CITY OF PORTLAND

Job ID: 2011-10-2354-ALTR

has permission to Second Floor Addition (Single Family Residence).

Conditions of Approval:

Marks 1st floor Layout

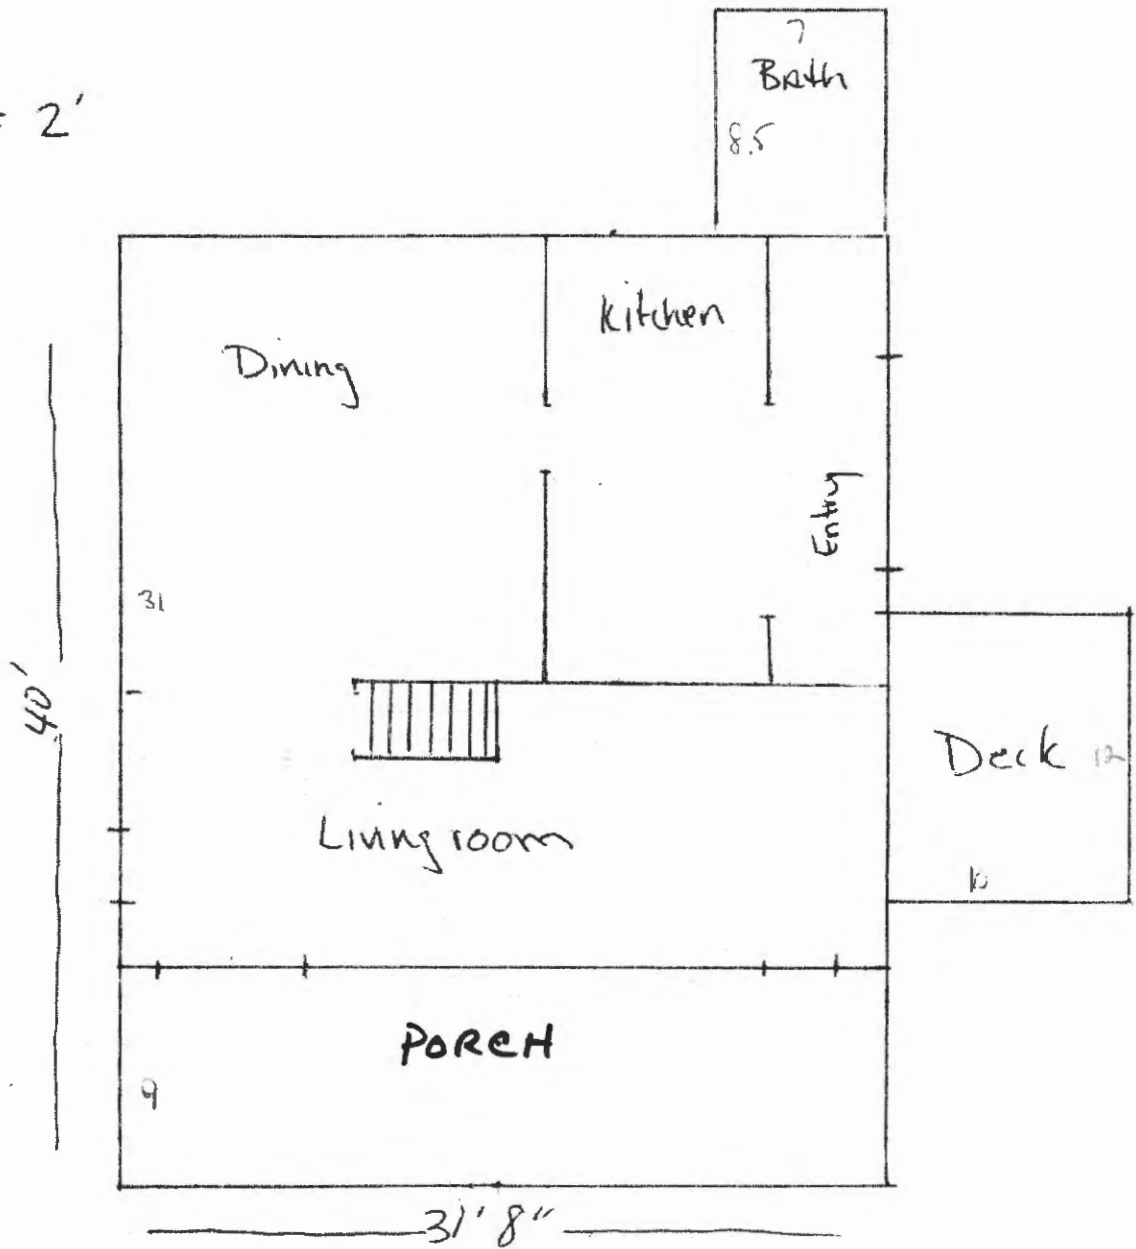
- 10. Girder spans and Header spans for exterior bearing walls shall comply with TABLE R502.5(1). The Contractor agreed that this shall include the existing header(s) beneath the proposed addition area and the second floor 8 foot 6 inch span, modification may be required.**

SECOND FLOOR JOIST PLAN (SUN PORCH CEILING) (PLATFORM FRAME)

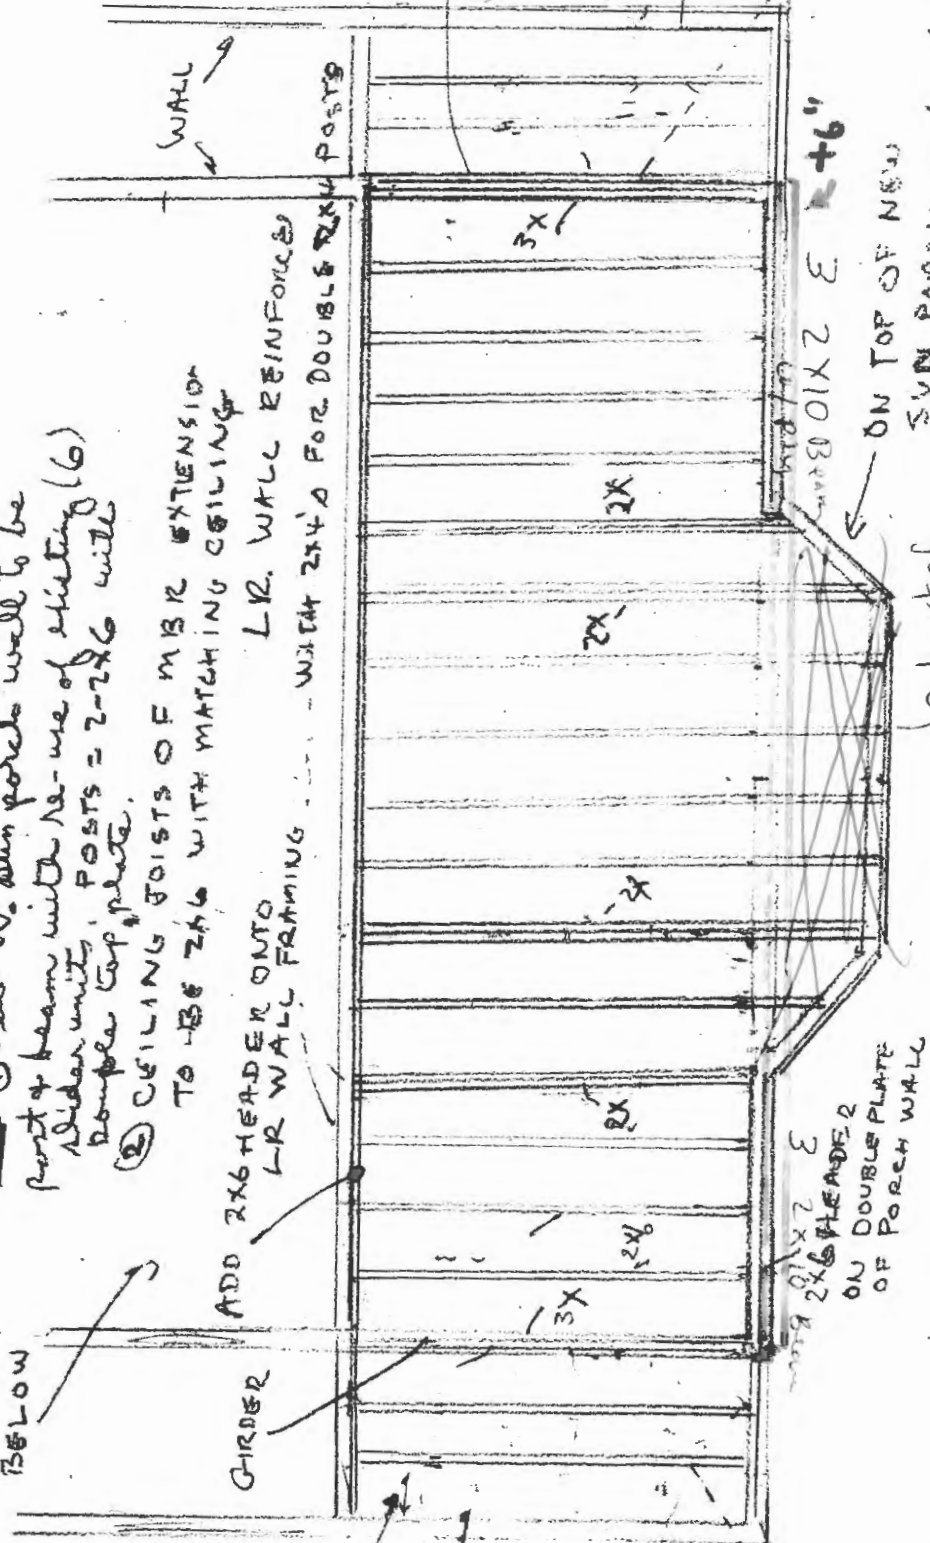
6. R502.6 Bearing. The ends of each joist, beam or girder shall have not less than 1.5 inches of bearing on wood or metal and not less than 3 inches on masonry or concrete except where supported on a 1-inch-by-4-inch ribbon strip and nailed to the adjacent stud or by the use of approved joist hangers. This shall include the Engineered Structural Ridge Beam.

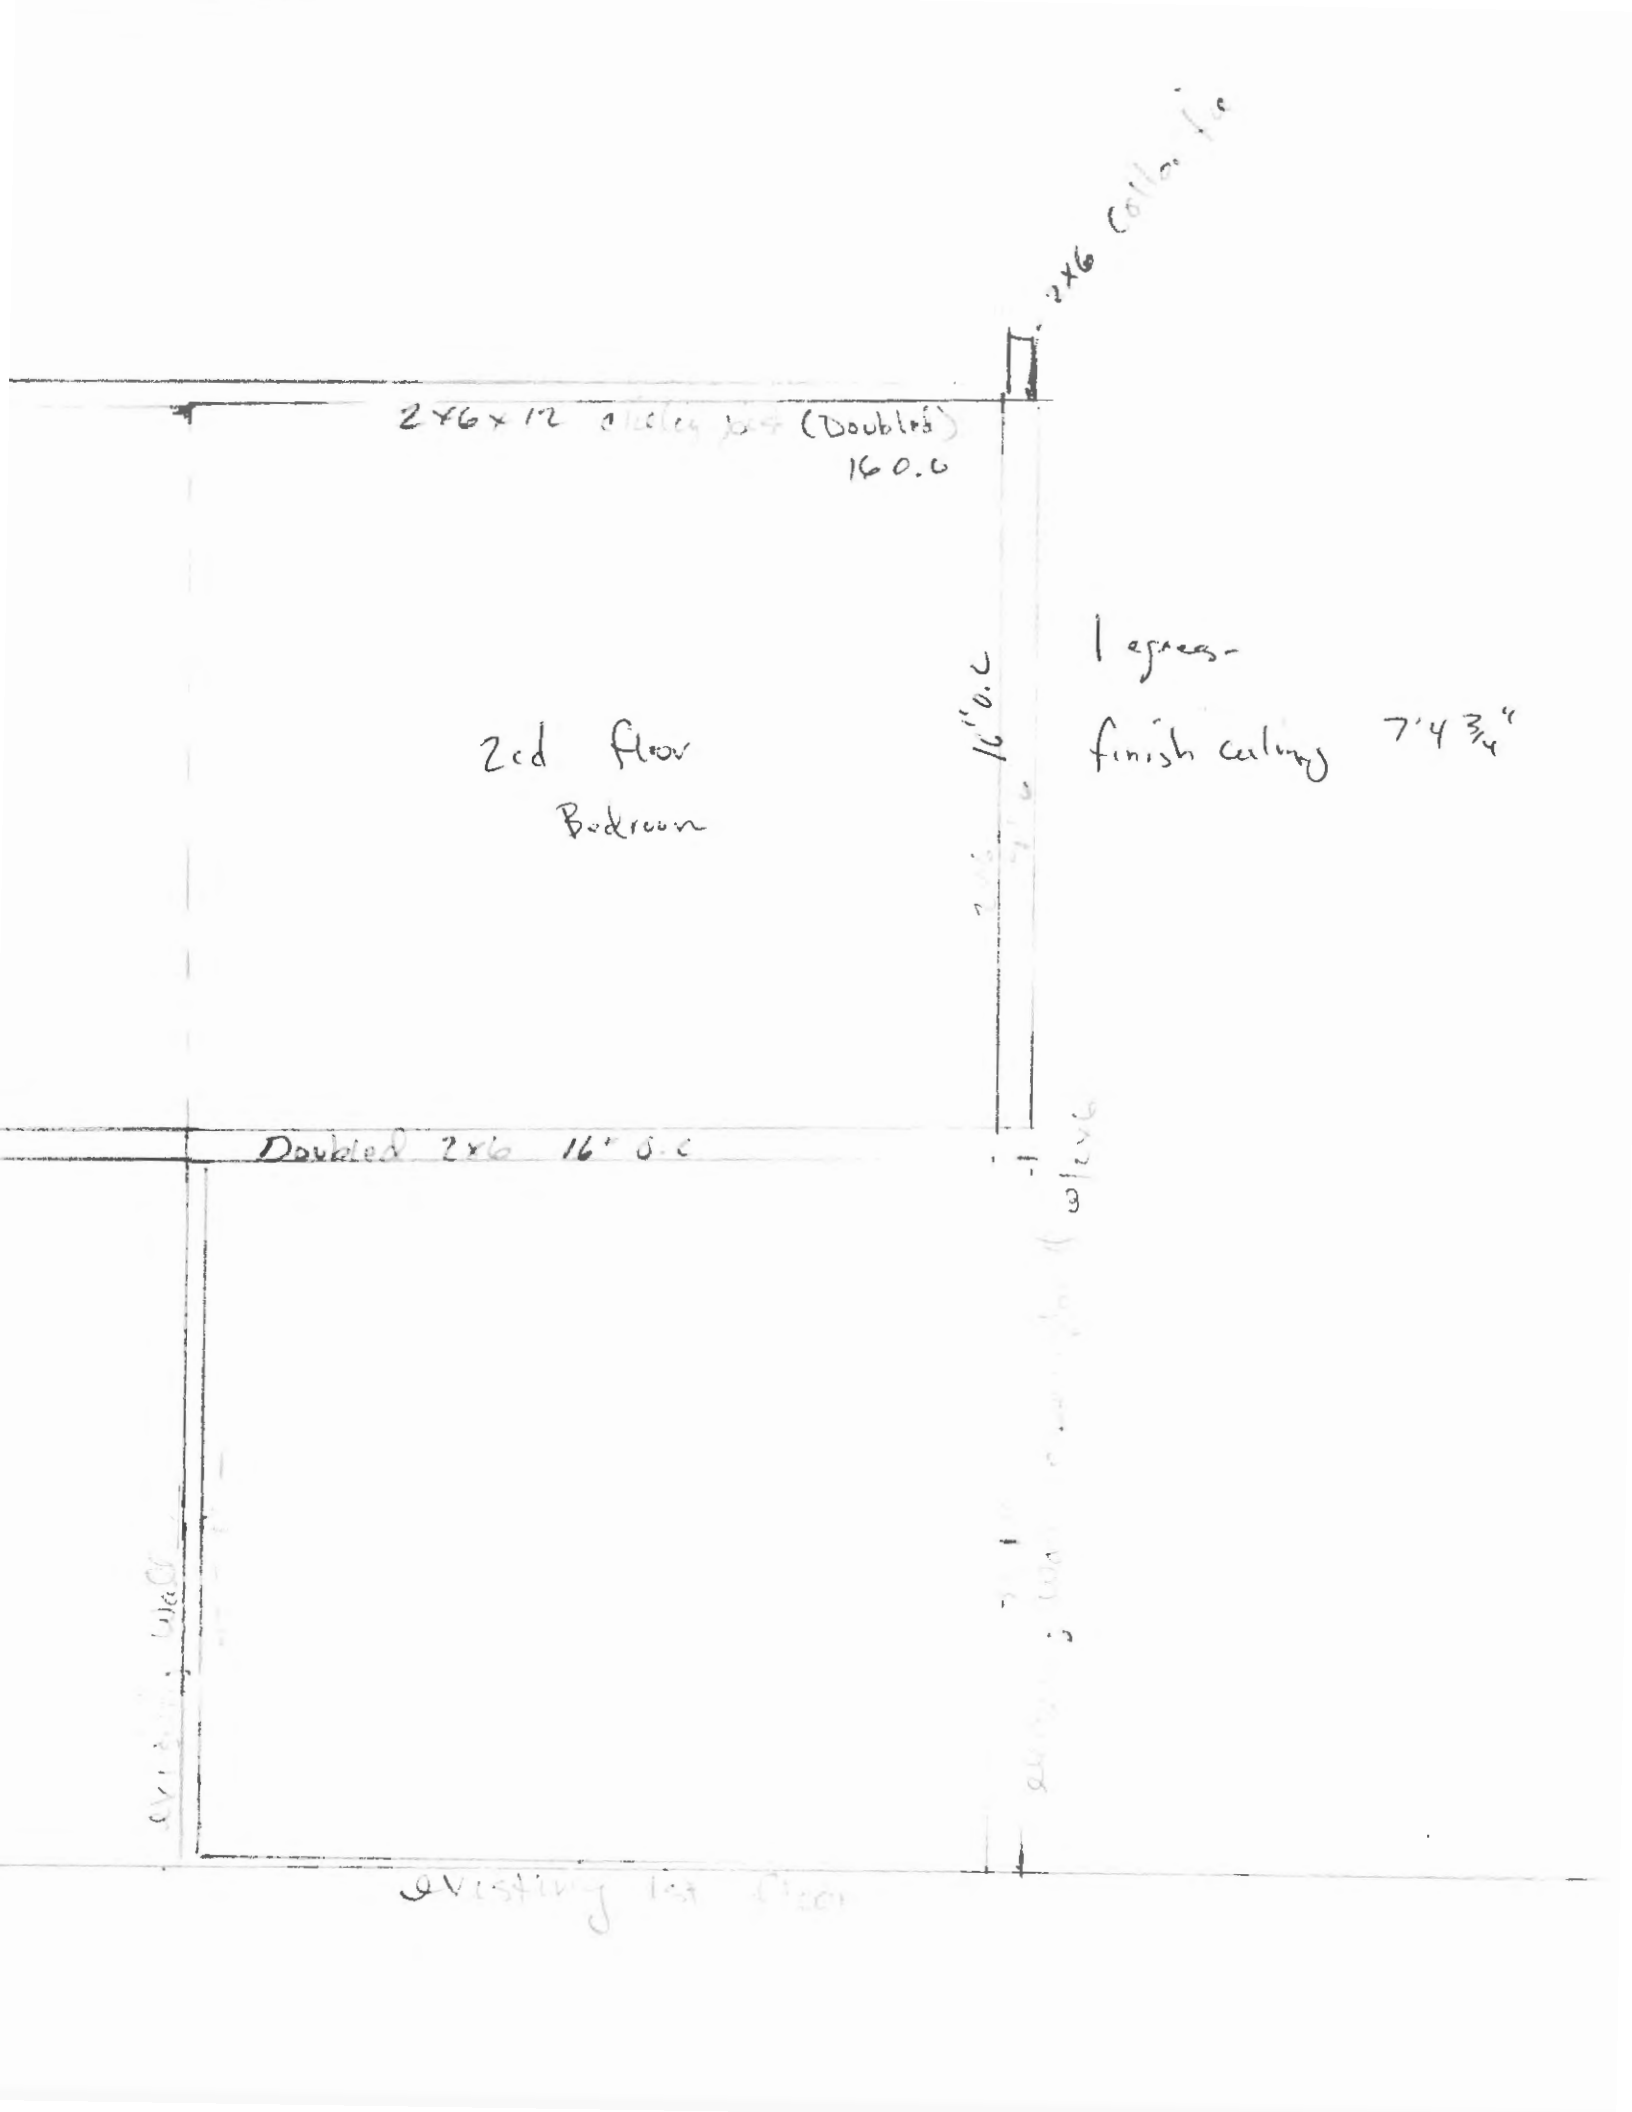
9. R305.1 Minimum height. Habitable space, hallways, bathrooms, toilet rooms, laundry rooms and portions of basements containing these spaces shall have a ceiling height of not less than 7 feet.

- a. 1. For rooms with sloped ceilings, at least 50 percent of the required floor area of the room must have a ceiling height of at least 7 feet and no portion of the required floor area may have a ceiling height of less than 5 feet.
